**From:** Tim Screen <Tim.Screen@Cherwell-DC.gov.uk>  
**Sent:** 17 May 2022 17:27  
**To:** Caroline Ford <Caroline.Ford@Cherwell-DC.gov.uk>  
**Subject:** 21/03177/F - Axis J9 Phase 3, Howes Lane, Bicester

PLANTING STRATEGY 0897-RFM-XX-00-DR-L-0003 P05

**Paper size**  
A1  
**Status**  
FOR INFORMATION  
**Drawing number**  
0897-RFM-XX-00-DR-L-0003  
© re-form landscape architecture

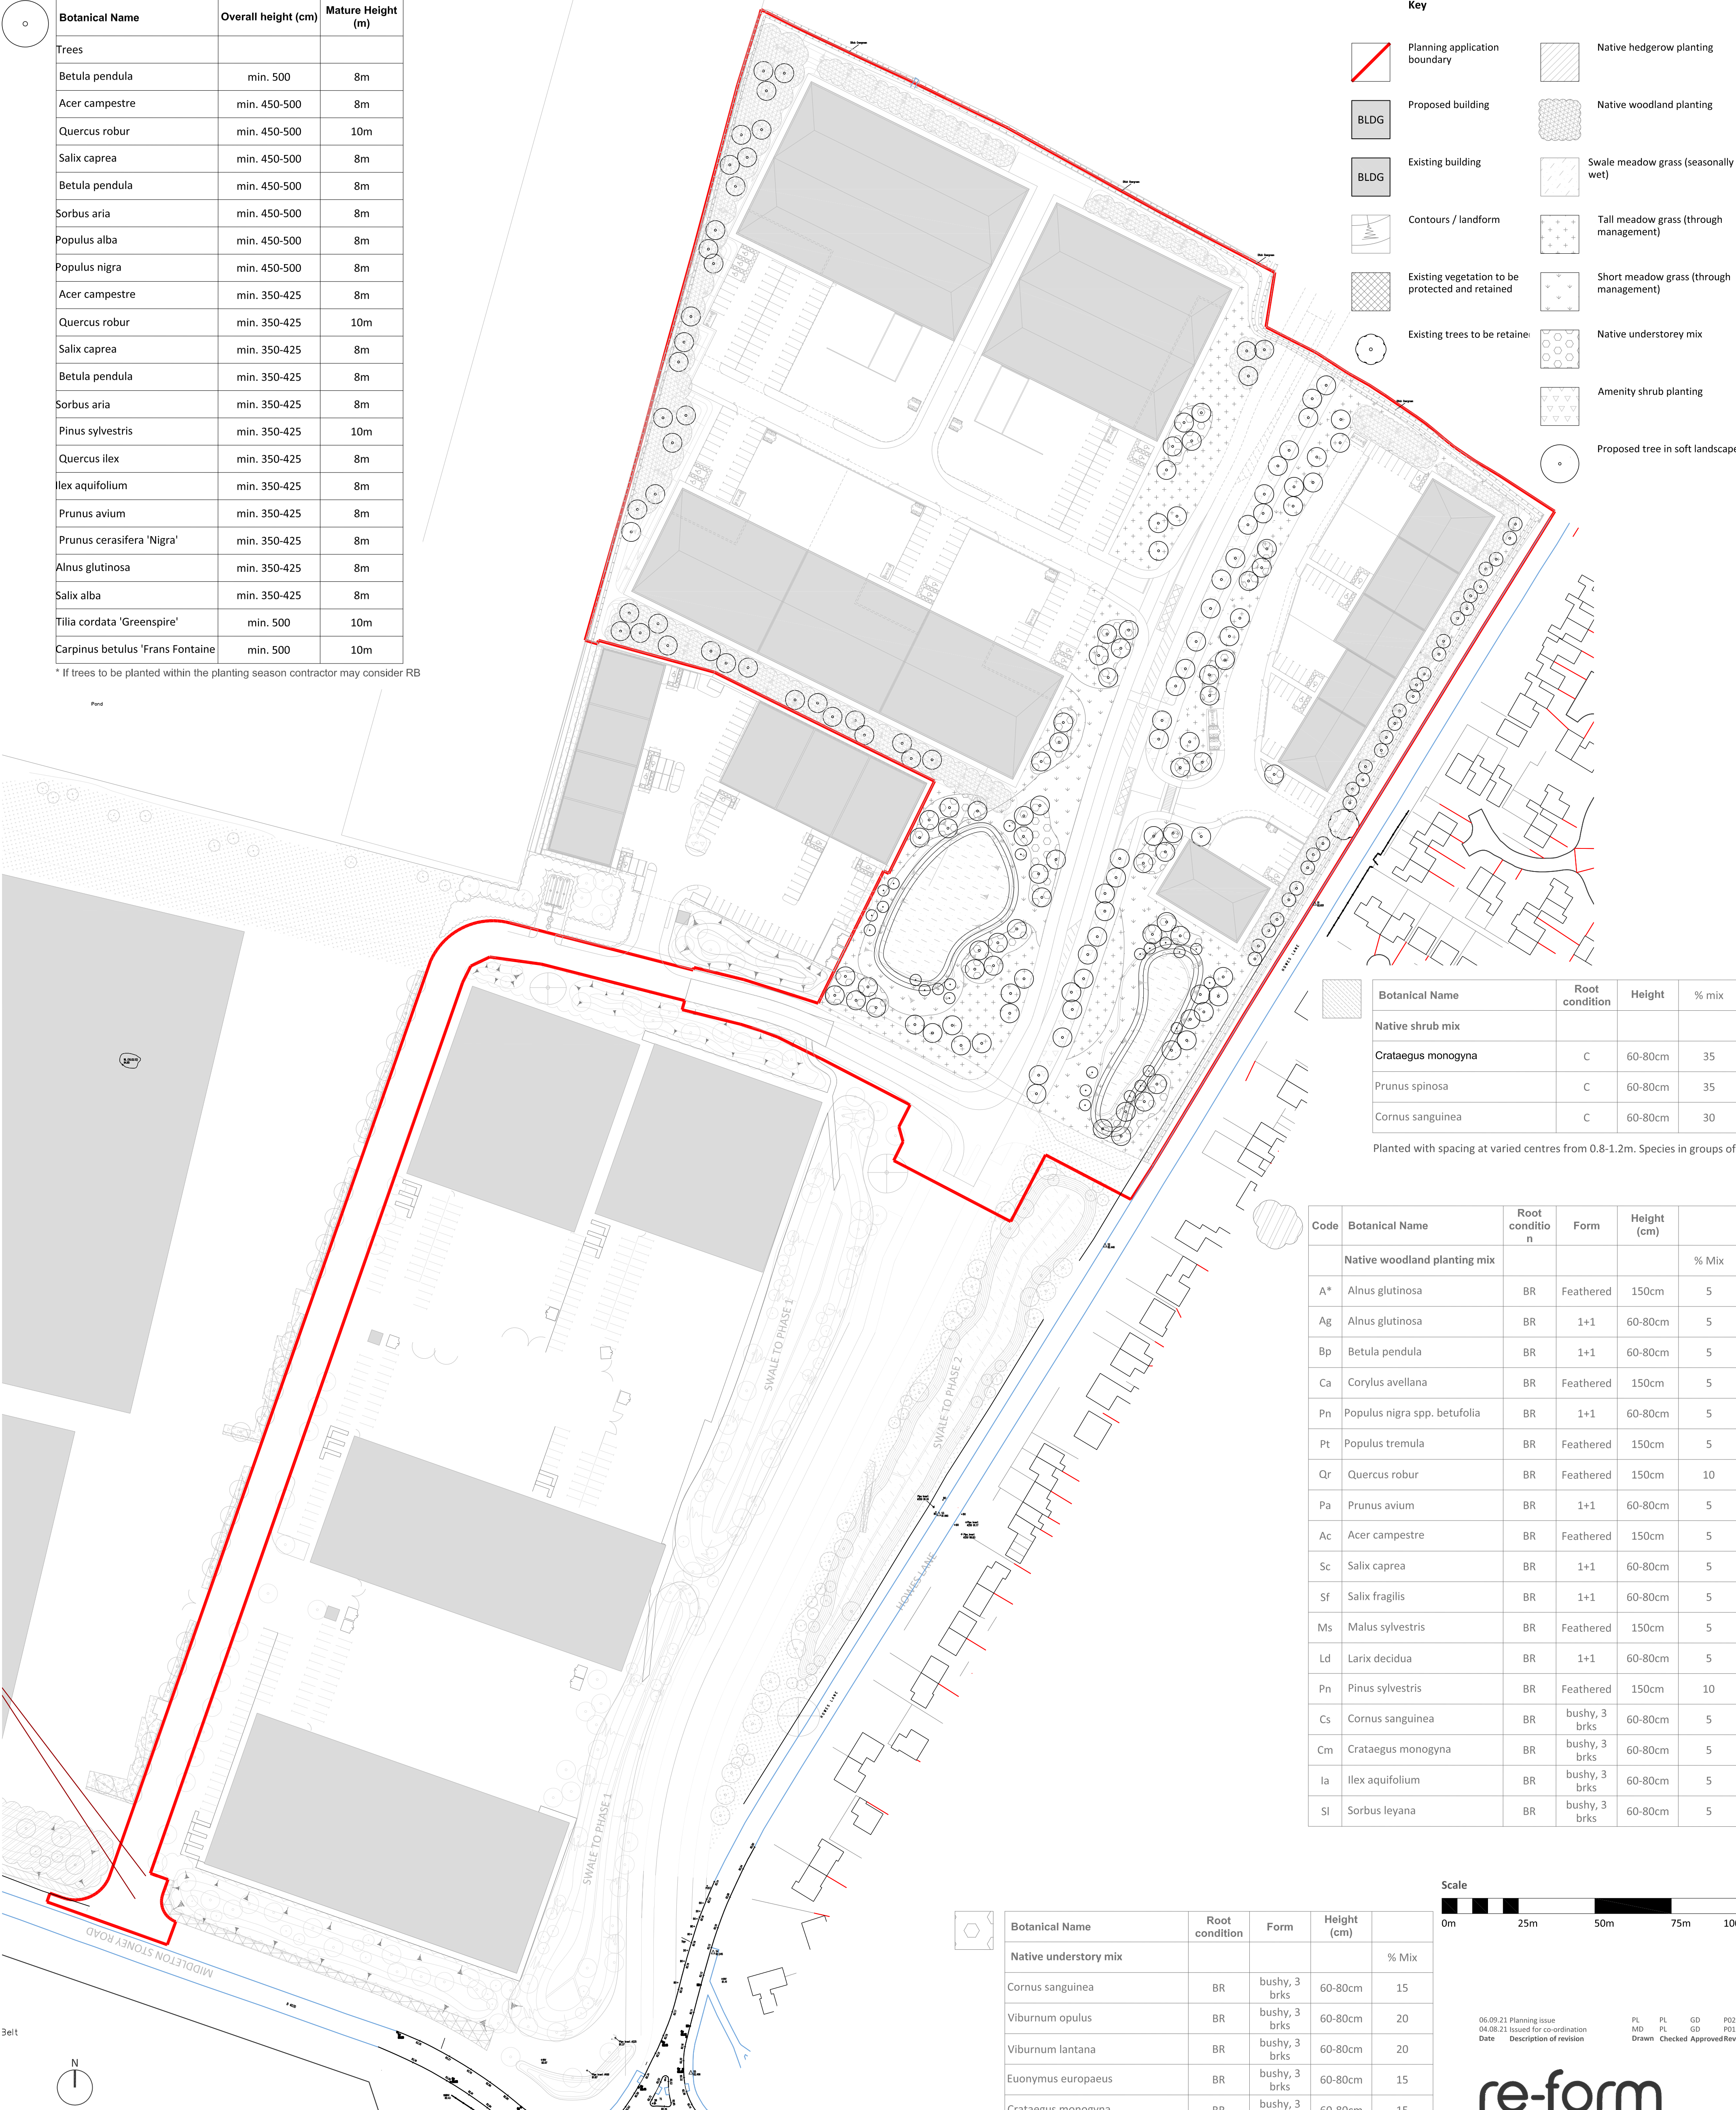
On consideration of the Phase 3 Technical Note Addendum indicates the widening of the SL Cycleway from 2.5 to 3.00 m the position of the trees should be at least 2 m away from the edge and root deflectors installed to prevent structural damage to the cycleway by tree roots.

Additional native trees such as oak and beech are required to be plant on the northern boundary, between Howes Lane the potential highway corridor to supplement the hedgerow, and provide the necessary visual mitigation of proposed development parcels for the benefit of roadside users and visual receptors on the PRoW.

Existing northern hedgerow is proposed to be supplemented with a new hedgerow planting in the northeast side of the boundary and intervening woodland between the units 4 and 5, which is welcome. However, it appears to be a conflict with swales indicated on the Proposed Site Plan in the Phase 3 Technical Note Addendum. Are there to be actual swales on this northern boundary, because this will mean there will be insufficient space woodland? I would prefer to see woodland for its value as a visual mitigator.

*Salix fragilis* (Crack Willow) has been removed from the scheme

*Sorbus leyana* has been removed from the scheme
